HOTHERSALL PARISH COUNCIL

Planning Application 3/2012/0157 – New multi-purpose agricultural building on land adjacent to Hothersall Lane.

Proposed West Elevation

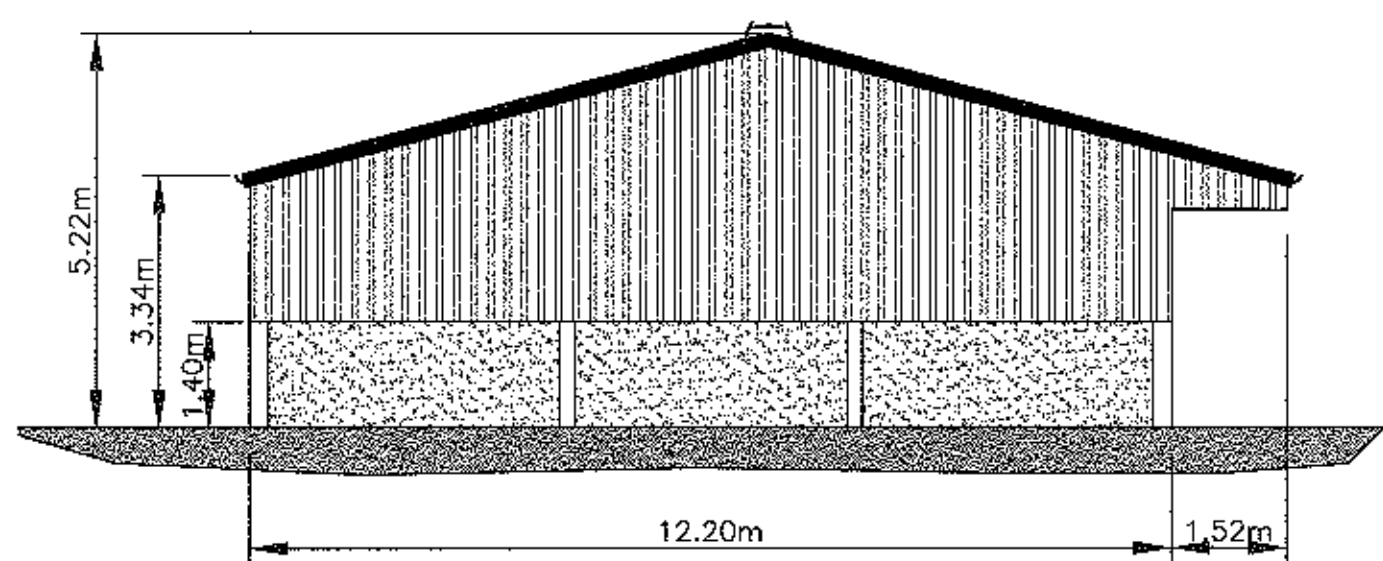
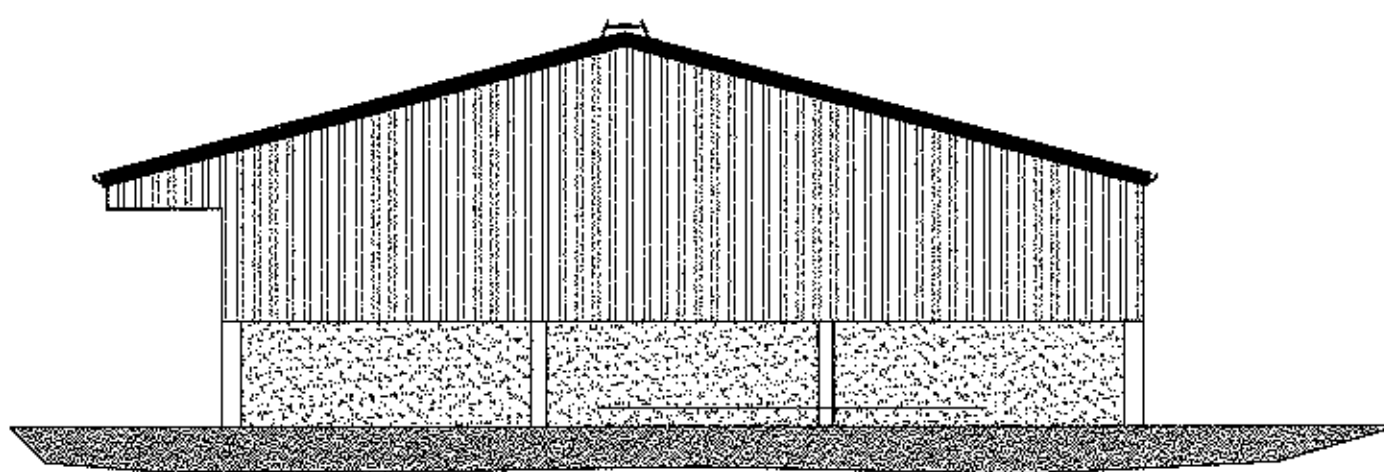
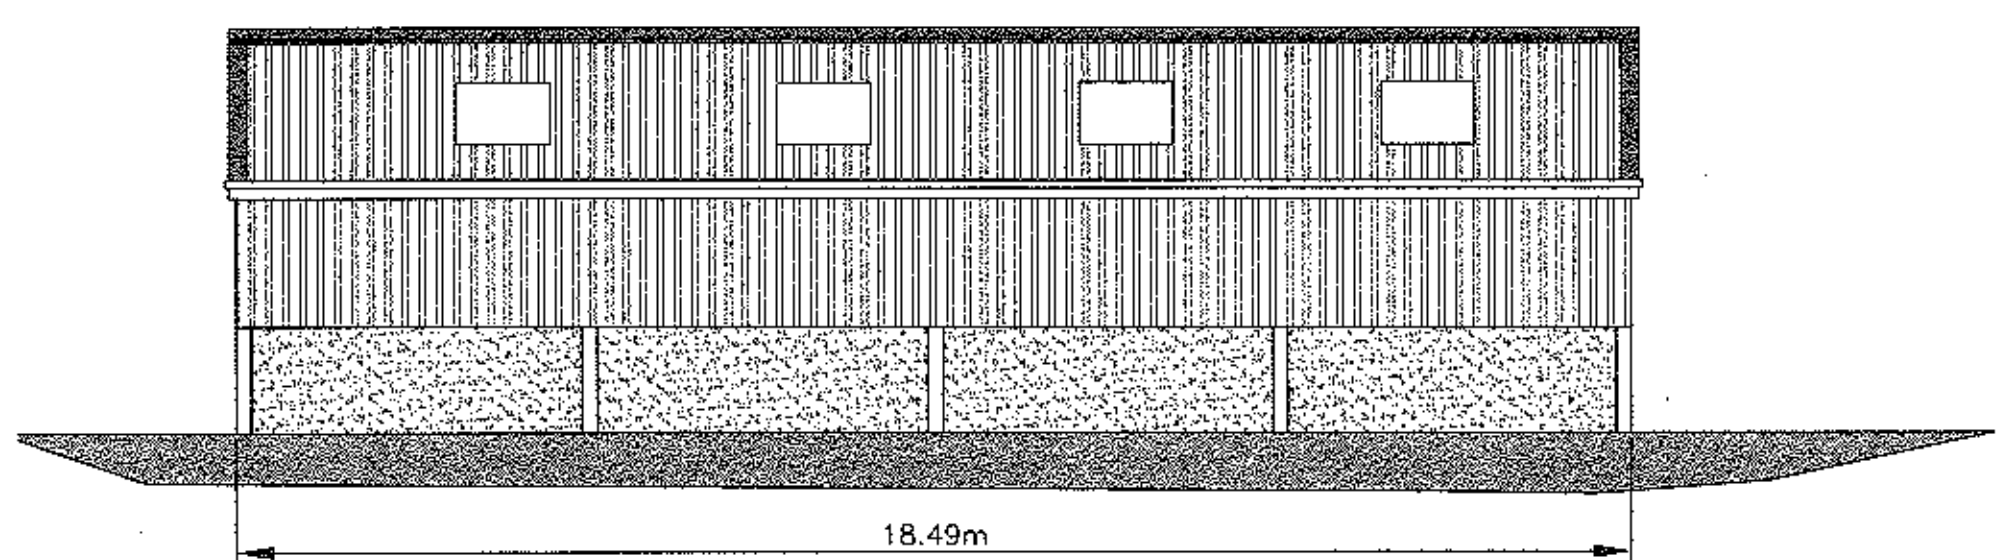
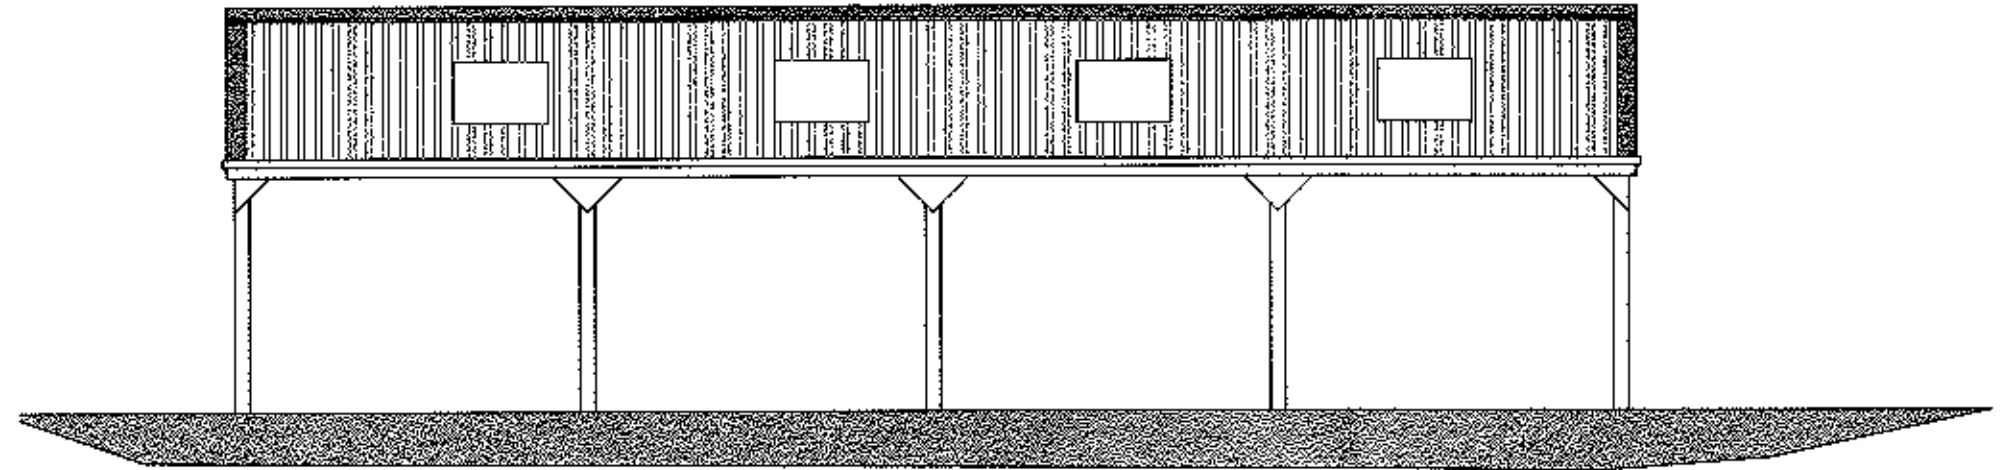
- 1 **The Elevations** (document marked 'B') are not in agreement. The north/south elevations place the long open side of the building facing towards the open field, whereas the east/west elevations place the long open side facing the road.
2. **The Measurements** (document 'A') do not tally with the distances given in the Design and Access Statement (document 'C'). Although not shown on the plan, the hedgerow is continuous past the proposed building. In document 'A' the distance from the corner of the building to what is presumably the lane side of the hedge is taken at an oblique angle to the hedge and is shown as 4.1m. From this it is difficult to fathom how the building will be sited '6m from the existing hedgerow as stated in Design and Access.

- (a) **Access** to the site will be from the existing field gate, not originally shown on the plan but marked in by me on document 'D.' This gate is roughly 130 metres from the new building but there is no provision for vehicle access to the new building by track or roadway.
